From: [Bill Iverson](#)
To: [Jeremiah Cromie](#)
Subject: KC Flood Control (SE-22-00053)
Date: Wednesday, June 15, 2022 7:36:53 AM
Attachments: [KittitasCounty_DraftPlans.pdf](#)

Old Cedars		
Old Cedars Flood Prevention		
11/18/2020		
Designed By:	C. Curtis	
Entered By:	C. Curtis	
County Engineer:	J. Fredrickson	
P.W. Director:	M. Cook	
Revision	Date	By

Federal Aid No.	
C.R.P. No.	
Plan and Profile	
PP-01	01 / 03

Channel & Road Profile

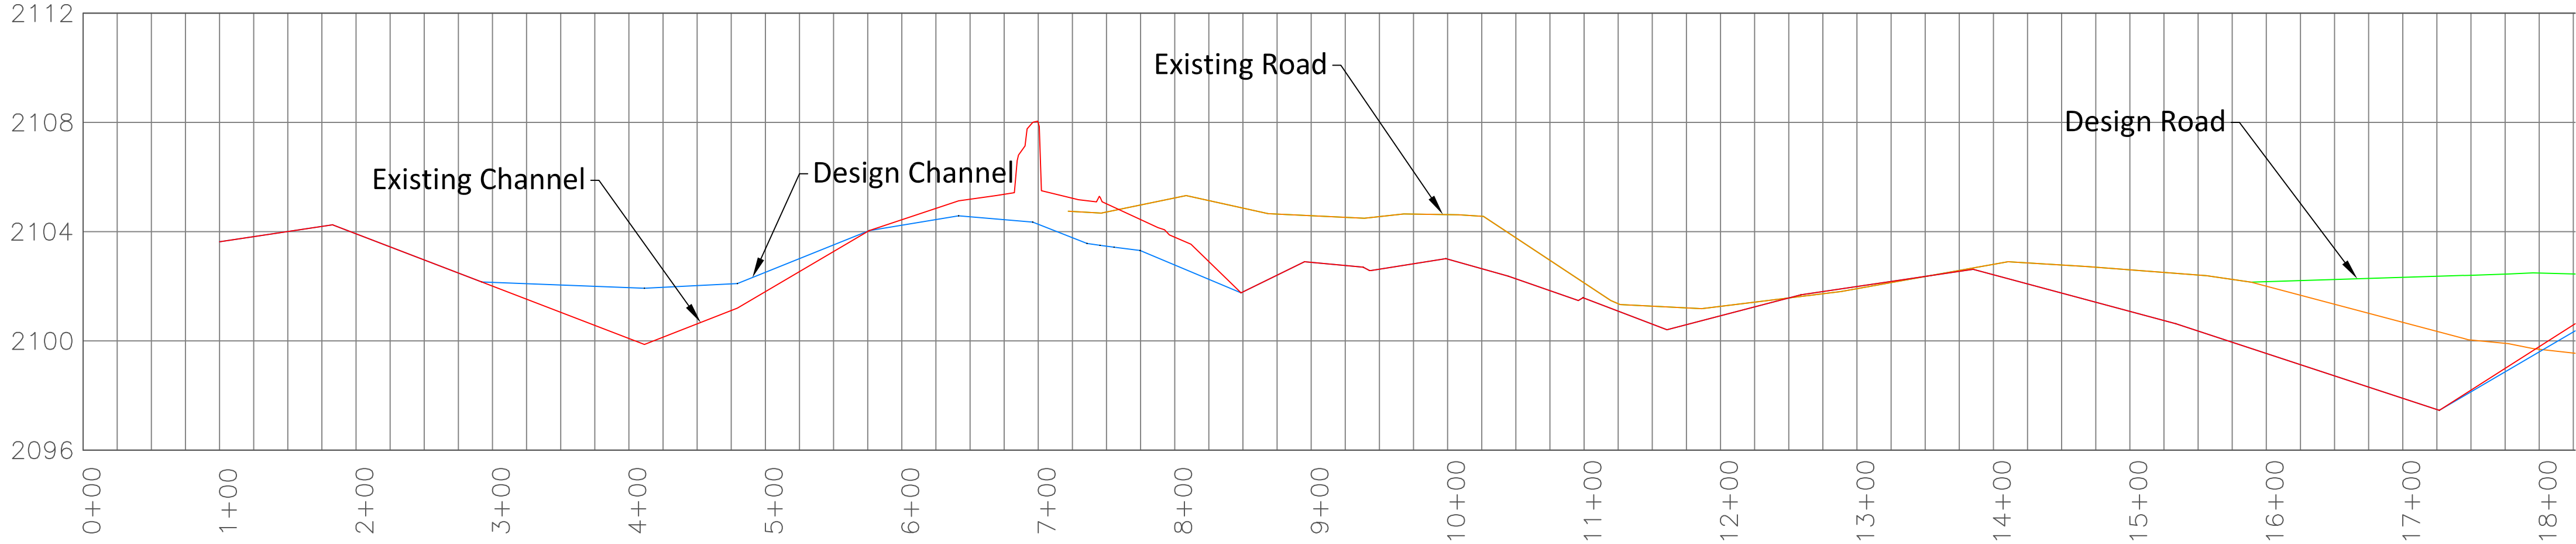
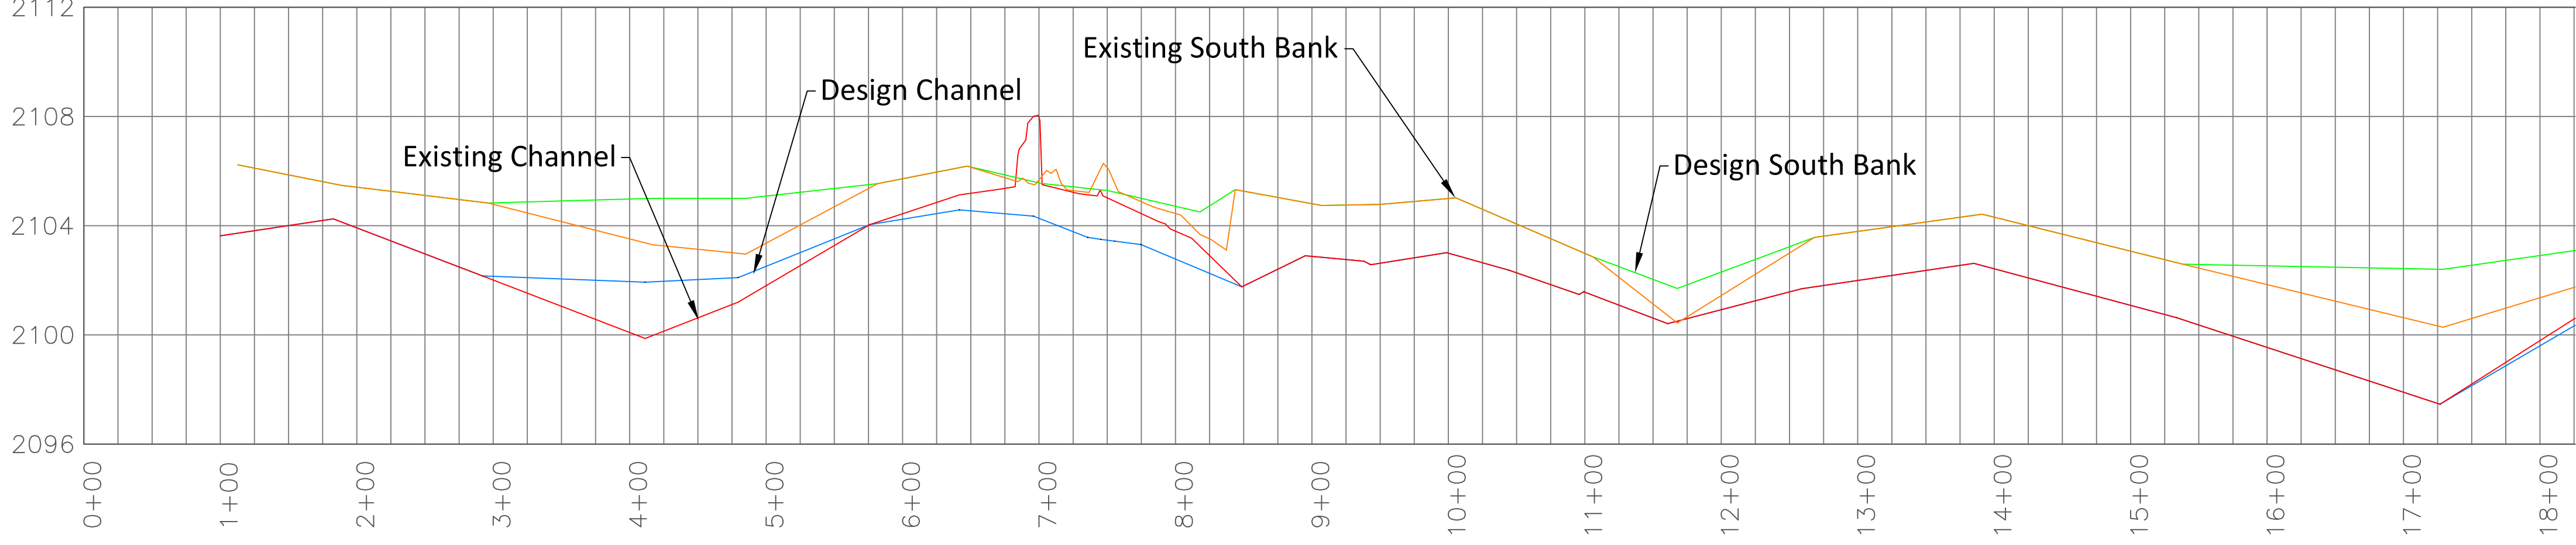
I attach an elevation profile (KittitasCounty_DraftPlans.pdf) that we received from Kittitas County a couple years ago, after we met with County engineers at this site. My concern is that the existing (unpermitted) adjacent road is consistently at a higher elevation than the proposed drainage ditch, which will make most of the work by Kittitas County a complete waste of time. Flood waters cannot reach the proposed improvements due to the impervious surface labelled "Existing Road" on attached document.

I request details of the County plan, showing how flood waters can ever even reach the proposed improvements. Most likely that would require installation of culverts under the "Existing Road" which crosses State Park property.
